Subject: FW: Planning Consultation on: AL/86/18/PL

Please note that we have had drainage engineer comments which although states no objection, there is a comment to say that:

B	show unit 3 plus drainage details.	8/18
A	Add drainage and delete storage of 2 caravans	5/13
Mr. J. Horton		
The Old Barn, Arundel Road, Fontwell. BN18 0SX		Richard Stubbs MRTPI
		TEL: 01243 825944
Mobile Home (3rd Unit)		06/12/B
1:2500	1:500	August 2018
		1 of 1

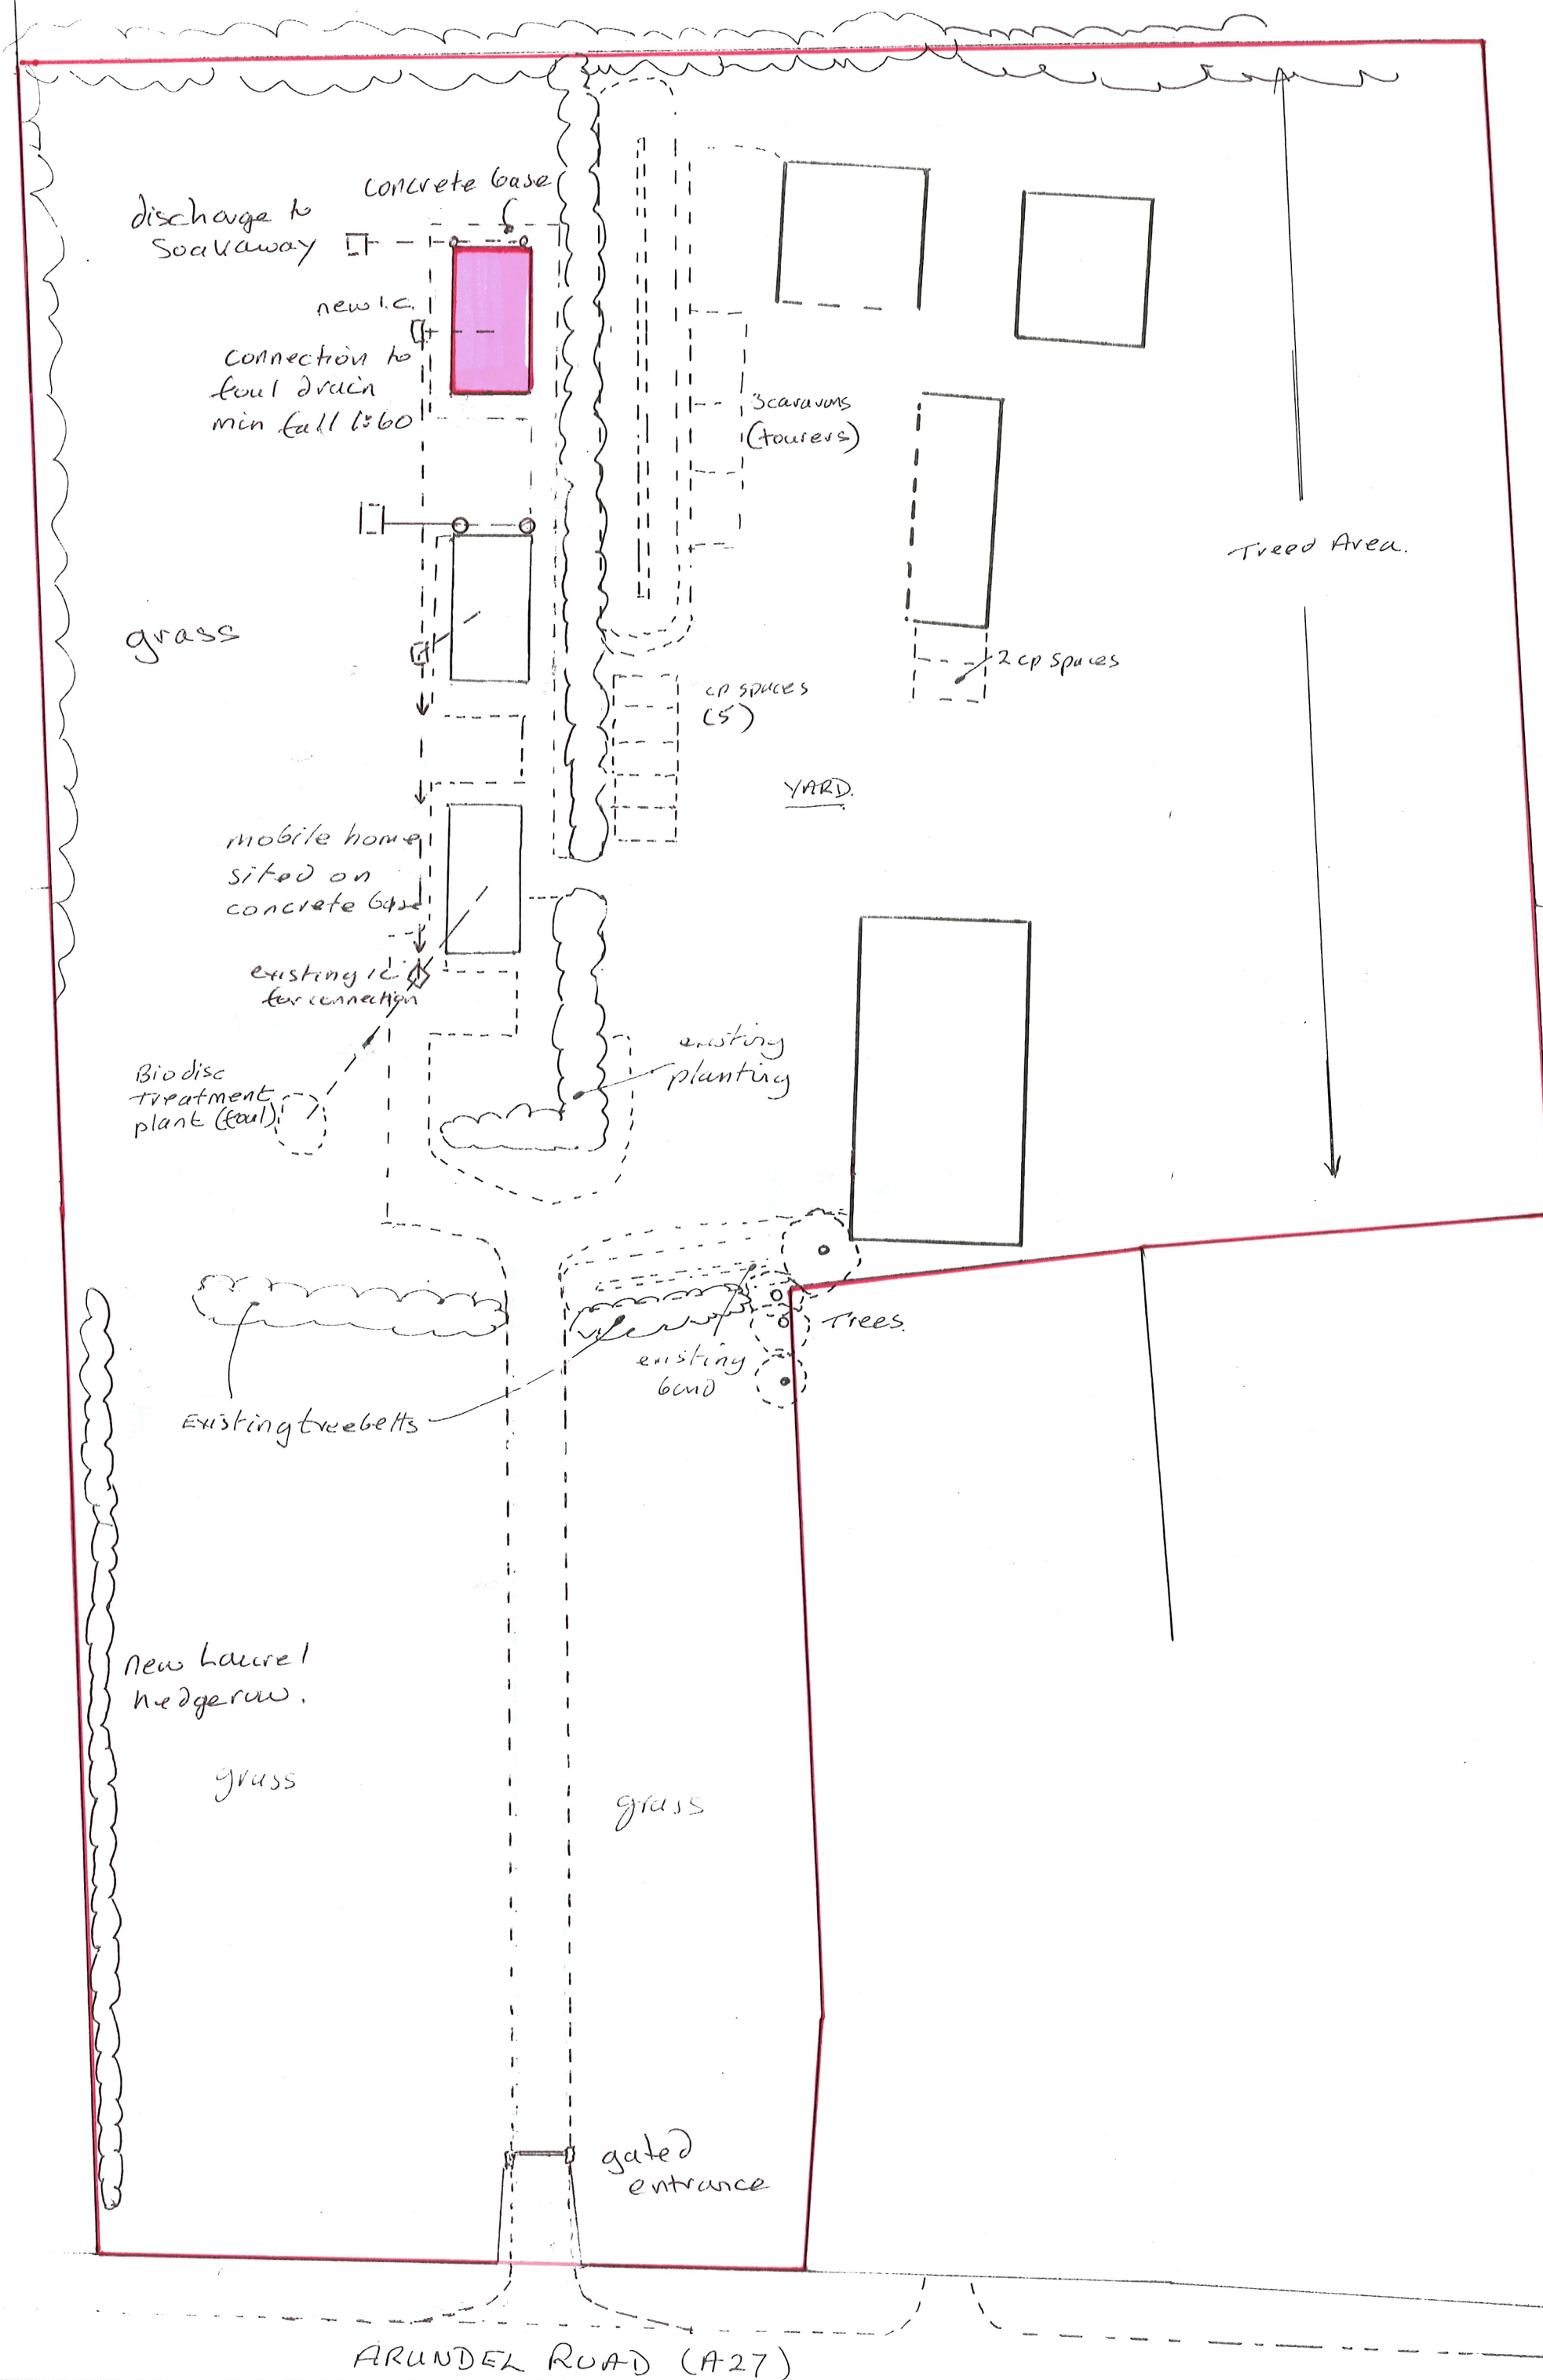
"It should also be noted that the site is within a groundwater source protection zone, therefore sufficient treatment of water to the ground will have to be demonstrated."

I have queried this and been told that It will need to be demonstrated that the SuDS scheme provides sufficient reduction in pollution concentrations before the water is allowed to infiltrate. This can be achieved via ensuring water is held for a set duration before it is allowed to infiltrate, by passing water through various medium such as permeable paving, etc
